***RE: AAA SEPTIC TANK (M14-D25). GRADING AND DRAINAGE PLAN SUBMITTAL
FOR BUILDING PERMIT APPROVAL. ENGINEER'S STAMP DATED 1-13-98.***

**RE: AAA SEPTIC TANK (M14-D25). GRADING AND DRAINAGE PLAN SUBMITTAL
FOR BUILDING PERMIT APPROVAL. ENGINEER'S STAMP DATED 1-13-98.**

GRADING & DRAINAGE PLAN

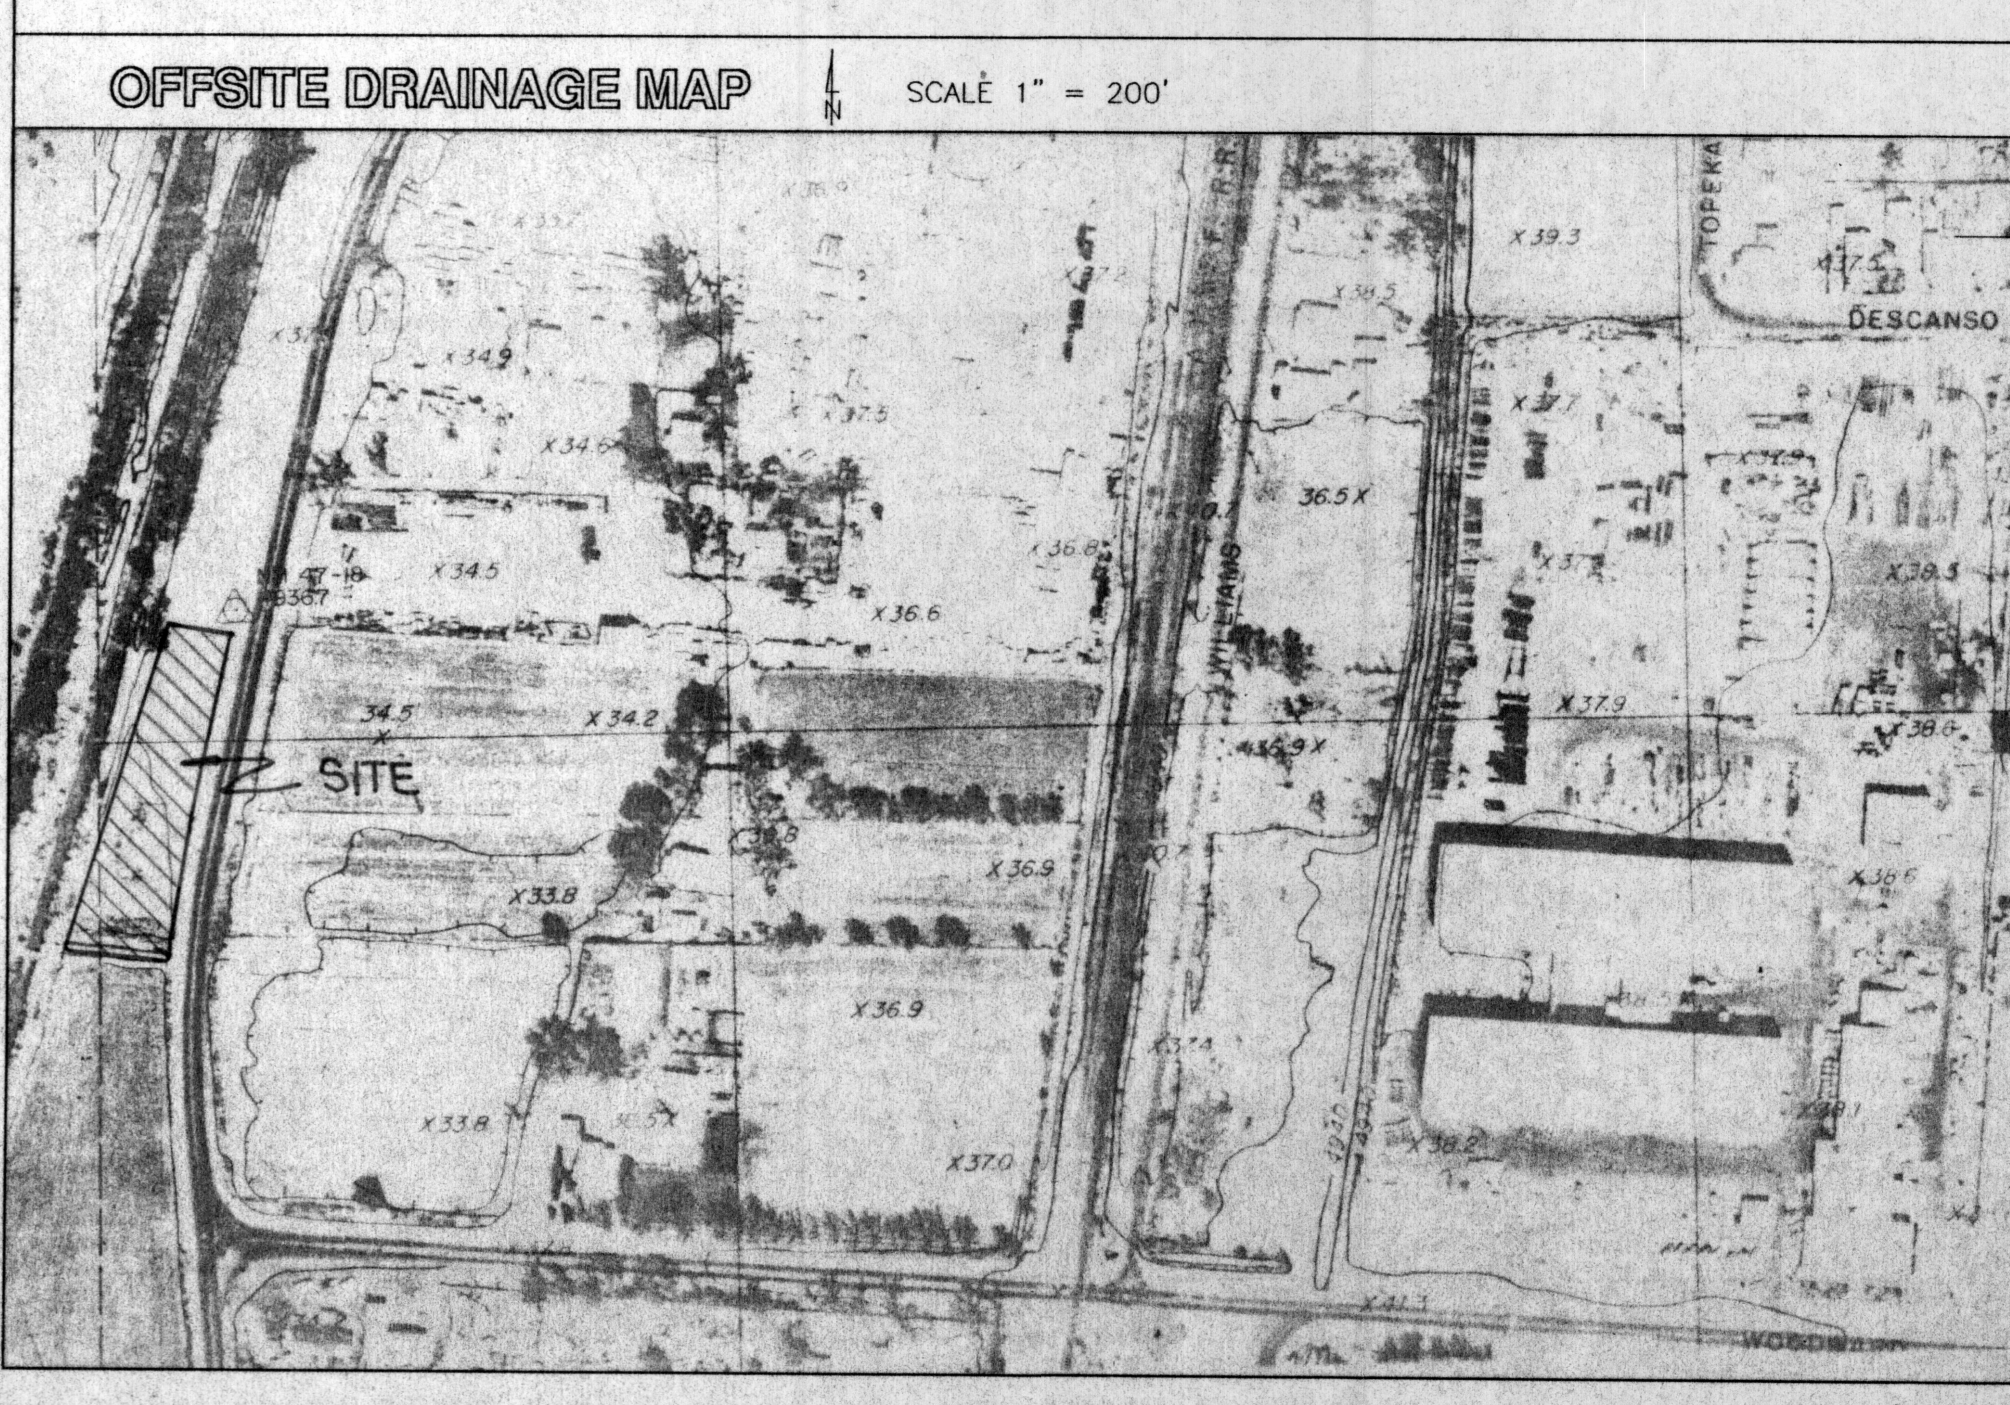
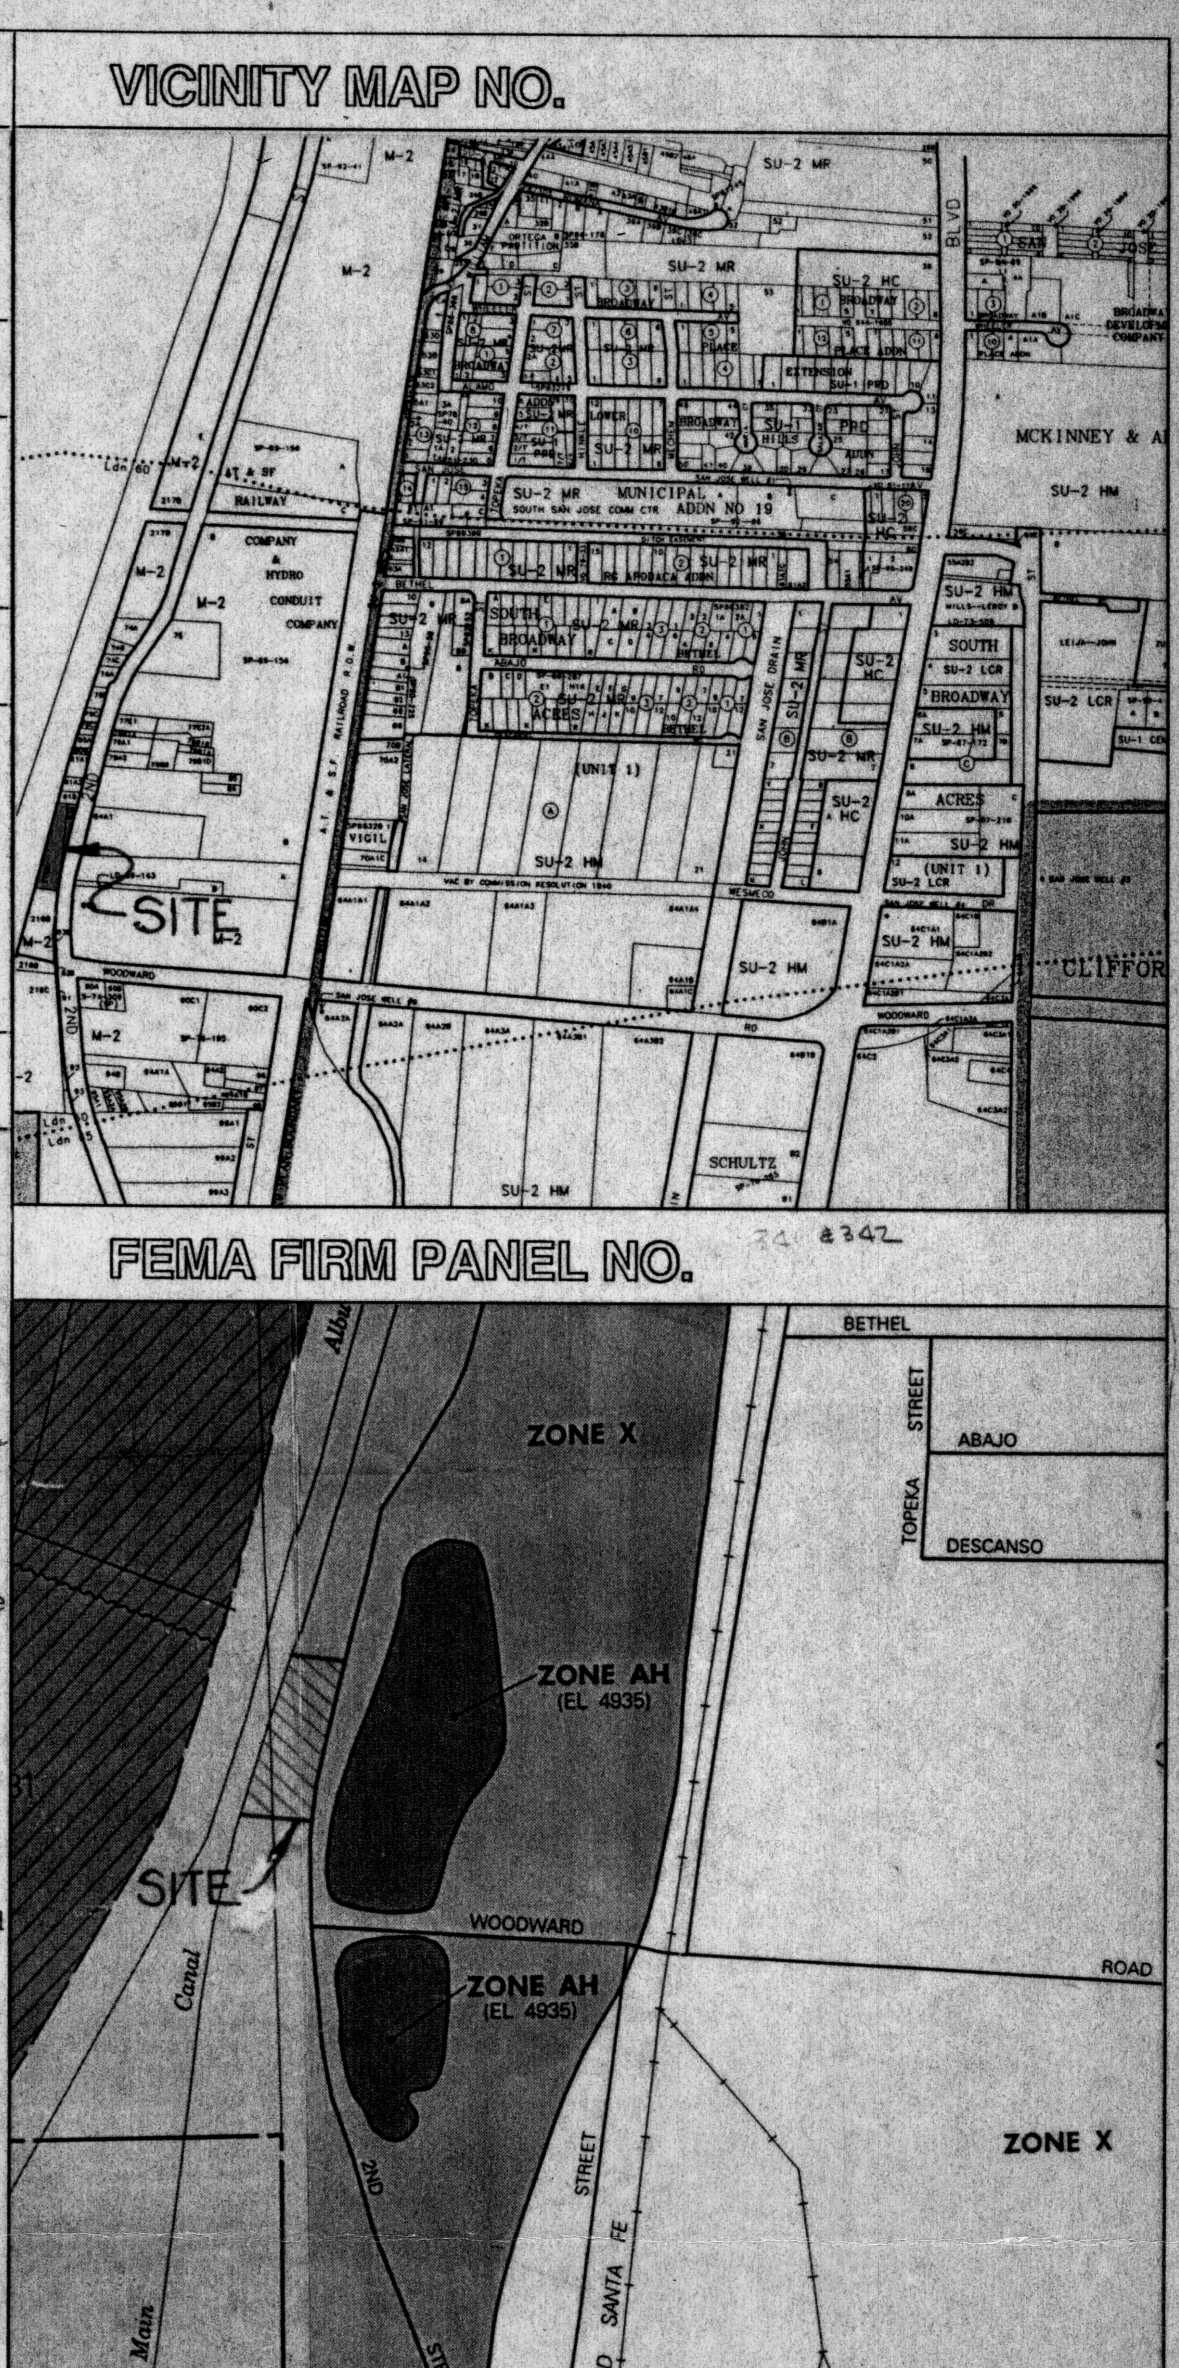
1. Per the City of Albuquerque Drainage Ordinance, retention ponding is not allowed.
2. Discuss the existing culvert shown perpendicular to and in Second Street, near the south property line.
3. Discuss offsite flows.

1. The grading and drainage plan submitted uses site retention as a drainage scheme as there is no outfall in the area. The system has been designed in such a manner that, a) the pond is completely evacuated at the end of the six hour rainfall period and, b) the system can be easily converted to either a detention system or a direct discharge system when a storm drain is constructed in 2nd Street in the future.

It is anticipated that 2nd street will be expanded and upgraded in the future when the Swartzman Farms area is developed. The development of this large area will require improvement in the roadway system, and equally important, the development will require a major drainage outfall. The Swartzman area is located approximately 1500 feet south of this development.

Until the improvement of 2nd Street is made there is no drainage pattern for the entire area.

2. The existing culvert crossing 2nd Street immediately south of the proposed development is an irrigation lateral coming off the Barr Canal.

3. The entire area is essentially flat. 2nd Street to the east, the Barr Canal to the west and an irrigation lateral to the south are all above the basic ground level and act as berms. There is an actual earth berm along the north. As with most of the agricultural area of the valley, the land is essentially flat

with streets and irrigation canals and laterals acting as berms. The offsite flow to the site is limited to the runoff from the west half of 2nd Street. This flow has been accounted for in the design of the retention system.
